SUBJECT: Engineering Review Comment
Mountain View Electric Association Inc. (The Association)

Project Name: Monument Academy – Minor Subdivision

Project Number: MS2110

Description: Proposed development of 1 lot and 4 tracts in approximately 62 acres located off at the southeast corner of State Highway 83 and Walker Rd. (Highway 105) in Township 11S, Range 66W, Section 15.

A PORTION OF THE E1/2 OF THE NW1/4 OF SECTION 15, TOWNSHIP 11 SOUTH, RANGE 66 WEST OF THE 6th P.M., EL PASO COUNTY, COLORADO

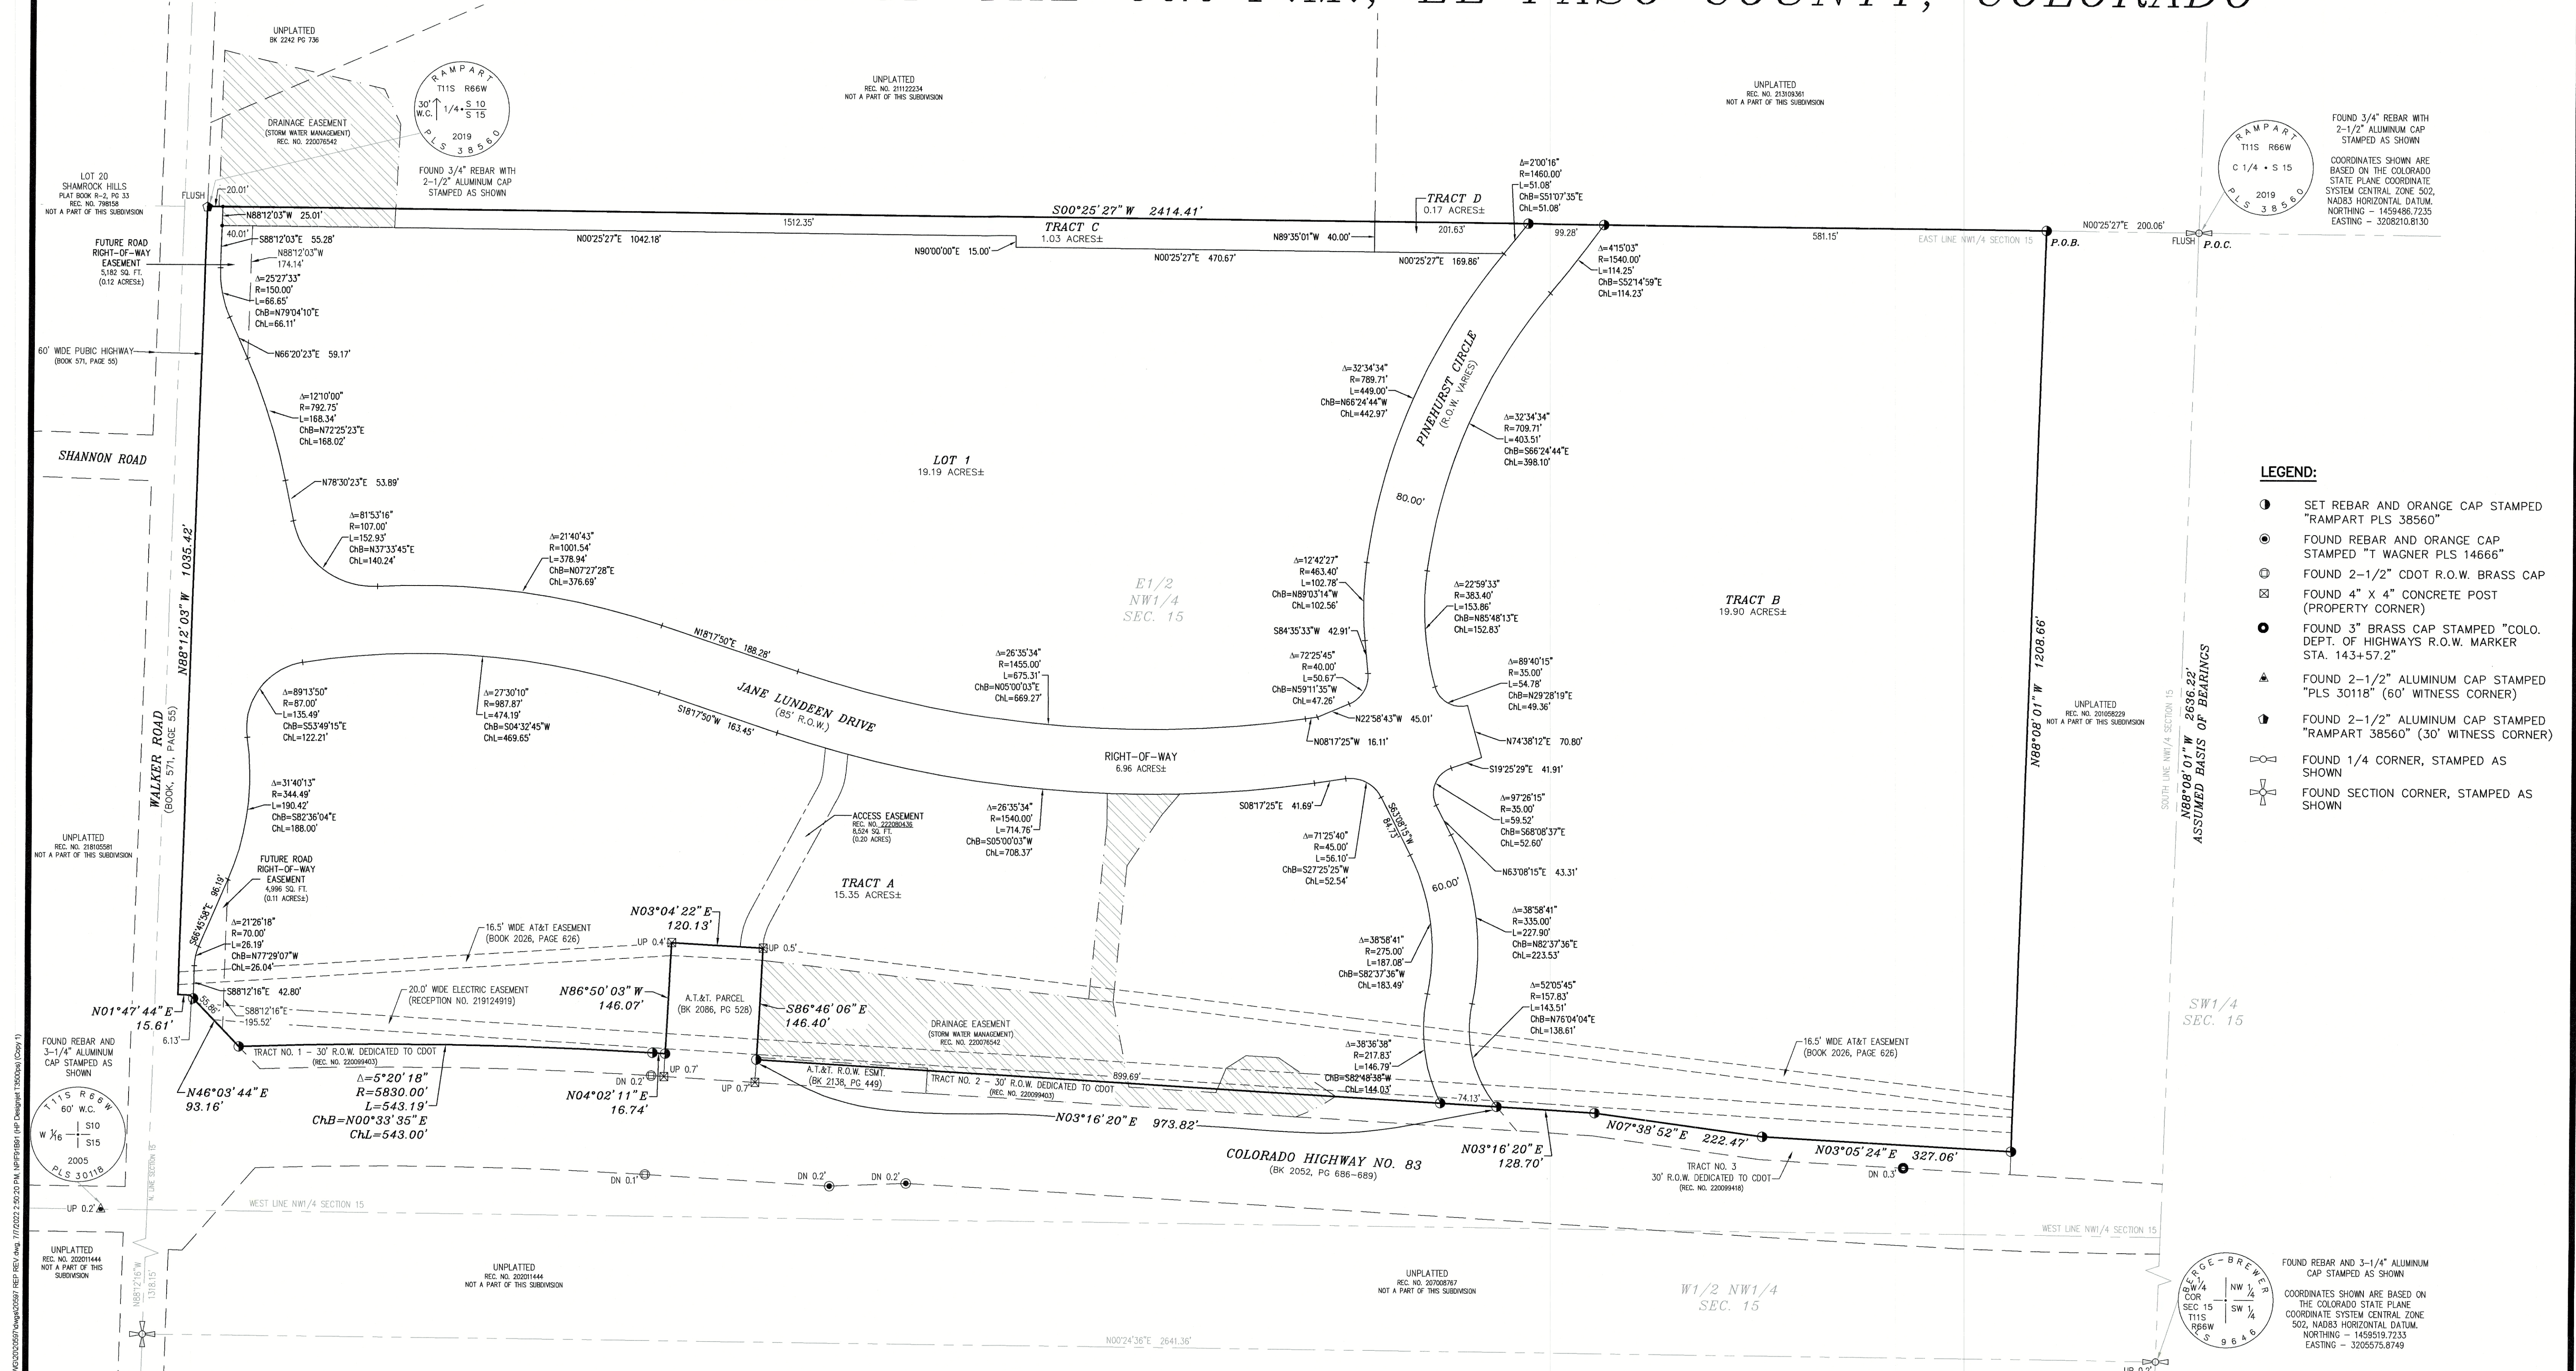
The Association requests a ten (10) foot front, side, and rear lot utility easement on the plat. The Association also requests the platting of the Association's existing facilities with easements on the plat. Additional easements may be required.
